Proposed State Significant Development (SSD-10446) - Luddenham Resource Recovery Centre

We are writing in response to the public exhibition of the Environmental Impact Statement (EIS) for a Resource Recovery Centre (Proposed Development) at 275 Adams Road, Luddenham (Site). The Proposed Development is a State Significant Development under the *Environmental Planning and Assessment Act 1979*.

- NOTES:
1. Lanes 3.5 m wide minimum.
 2. The left turn bay is 90 m long with a taper of 30 m.

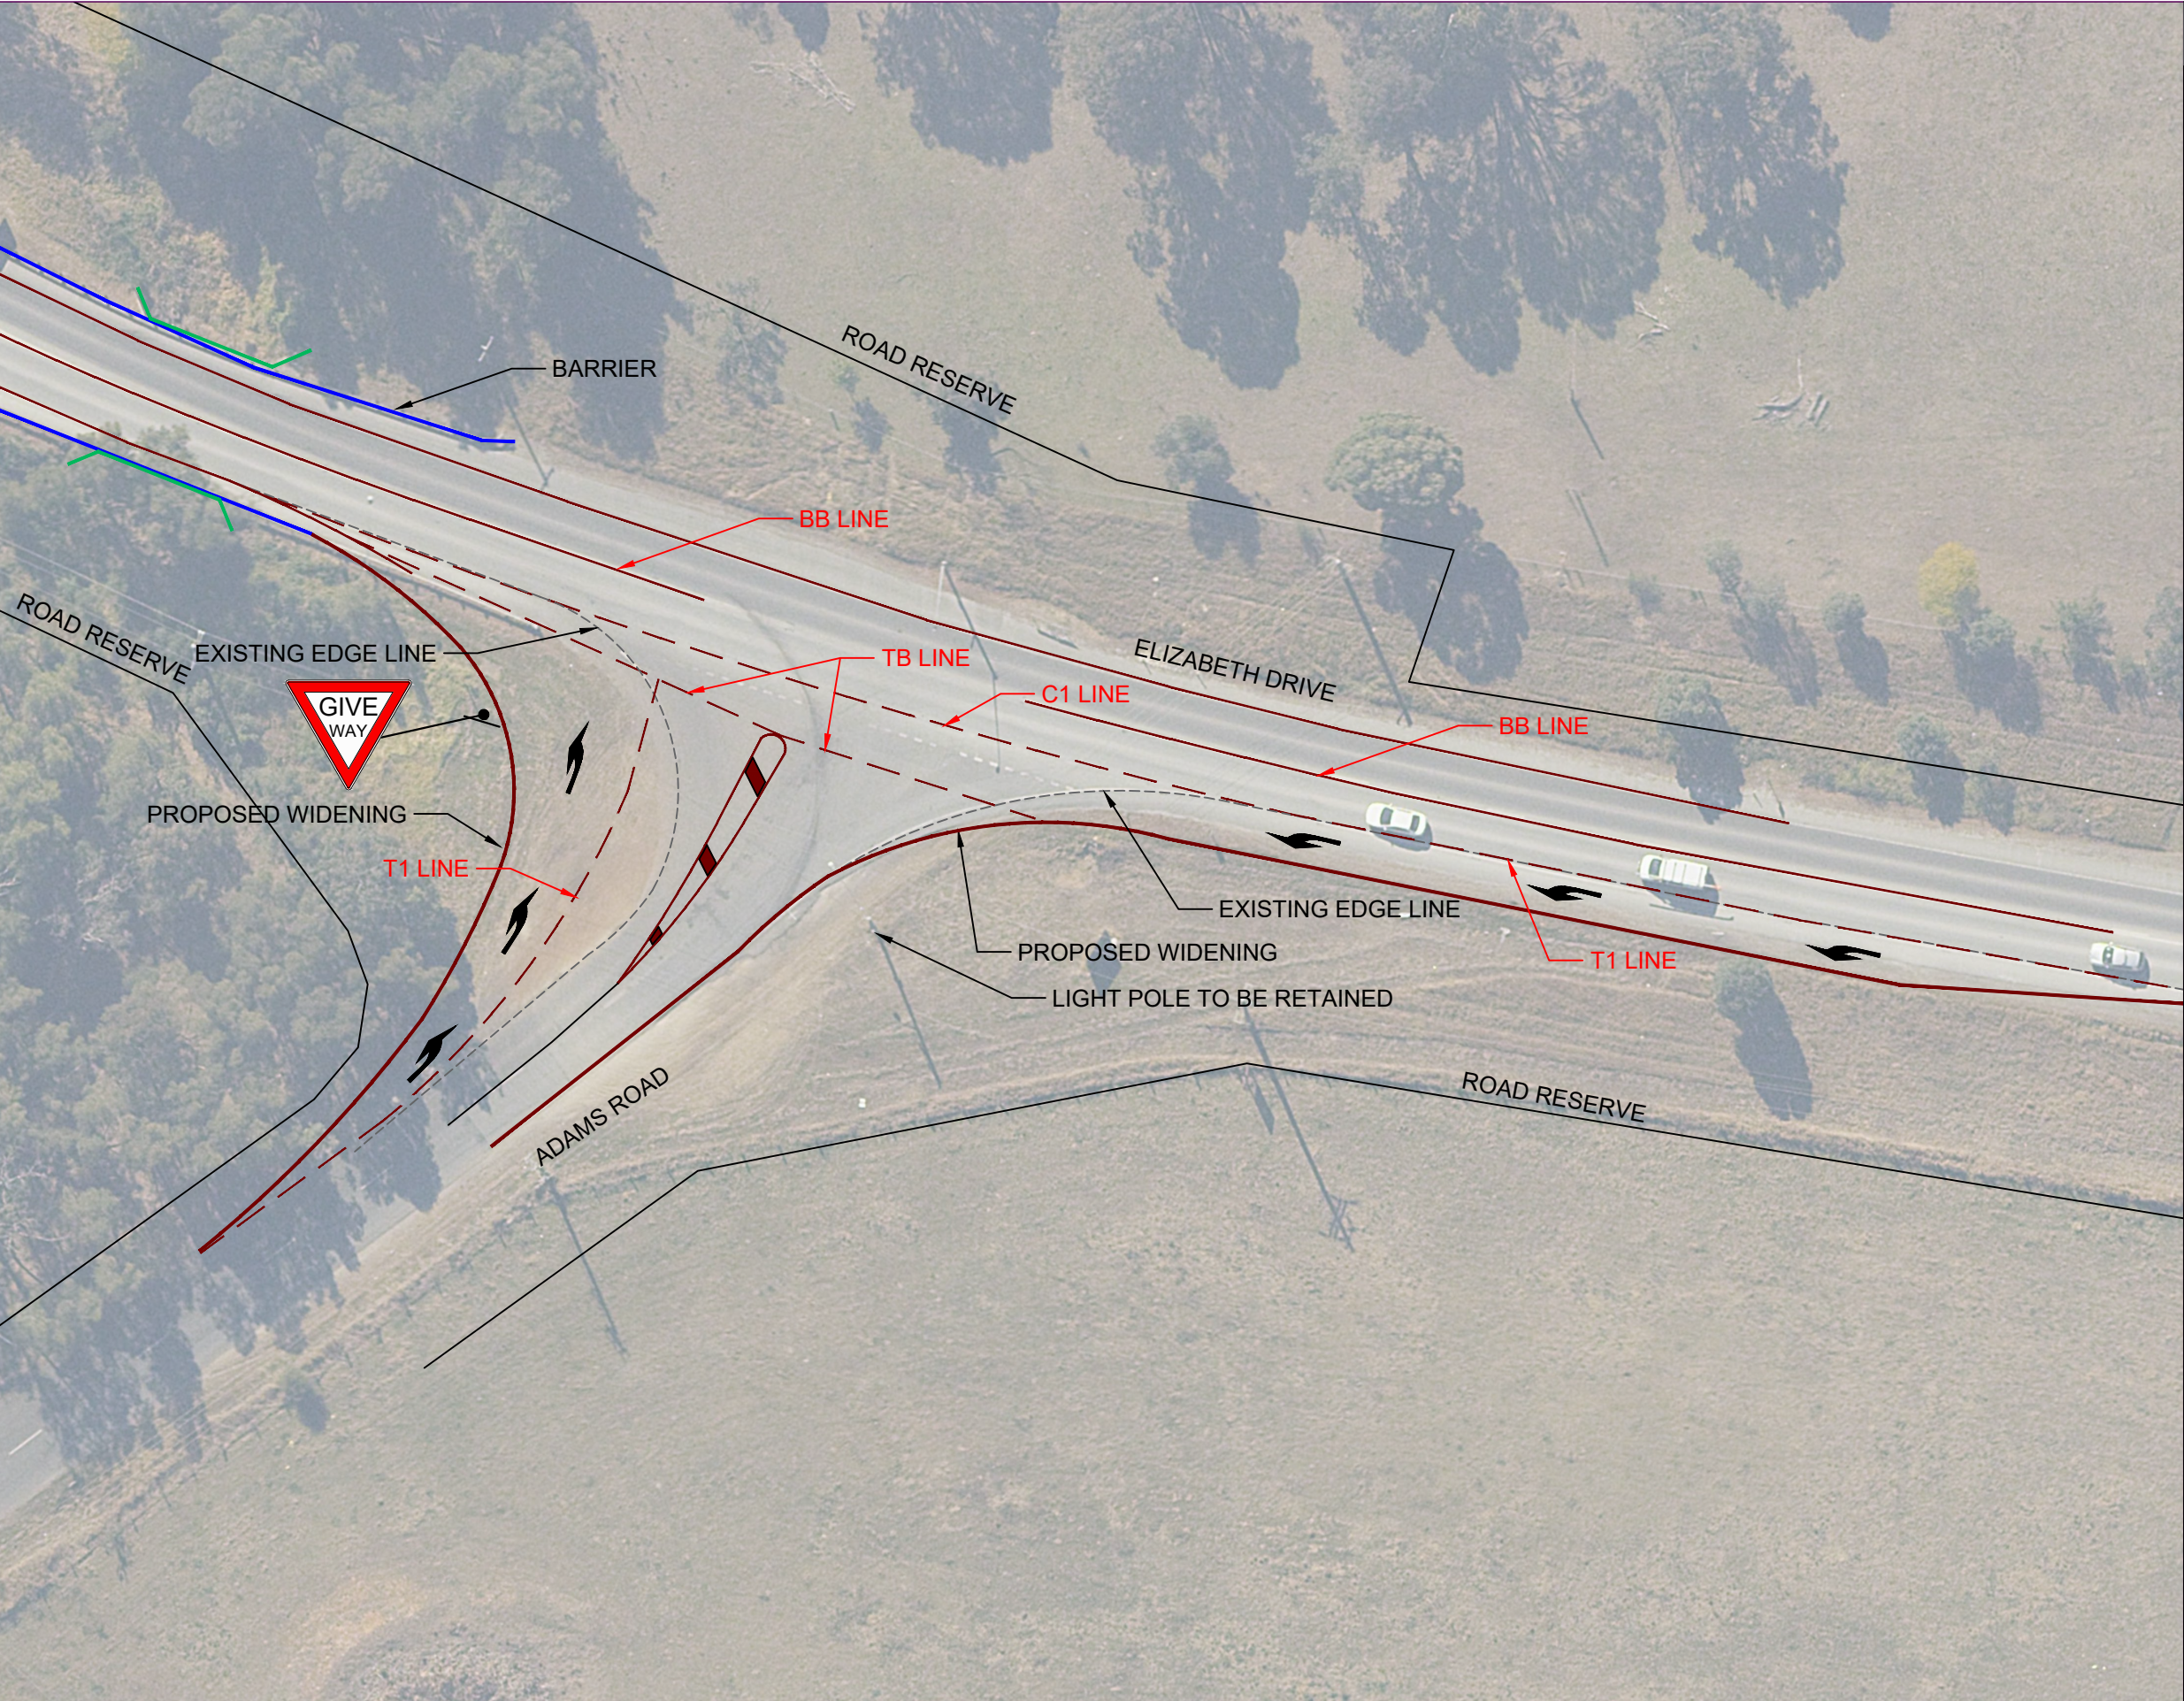
14. Therefore, the EIS should assess the impacts of the Proposed Development based on the current design and capacity of Elizabeth Drive, including the suitability of the proposed use occurring before any upgrade to Elizabeth Drive. In particular, the intersection of Adam Road and Elizabeth Drive may need to be upgraded as a result of the Proposed Development to ensure the safe operation of this intersection.
15. The traffic assessment, particularly the traffic volumes do not appear to have taken into account future development envisaged by the WSAP and therefore the impact to network capacities and intersection performances may not have been properly assessed. In addition, it is unclear if the assessment has taken into account construction traffic associated with the major infrastructure projects occurring in the vicinity of the site such as the Airport, M12 and Metro Rail.
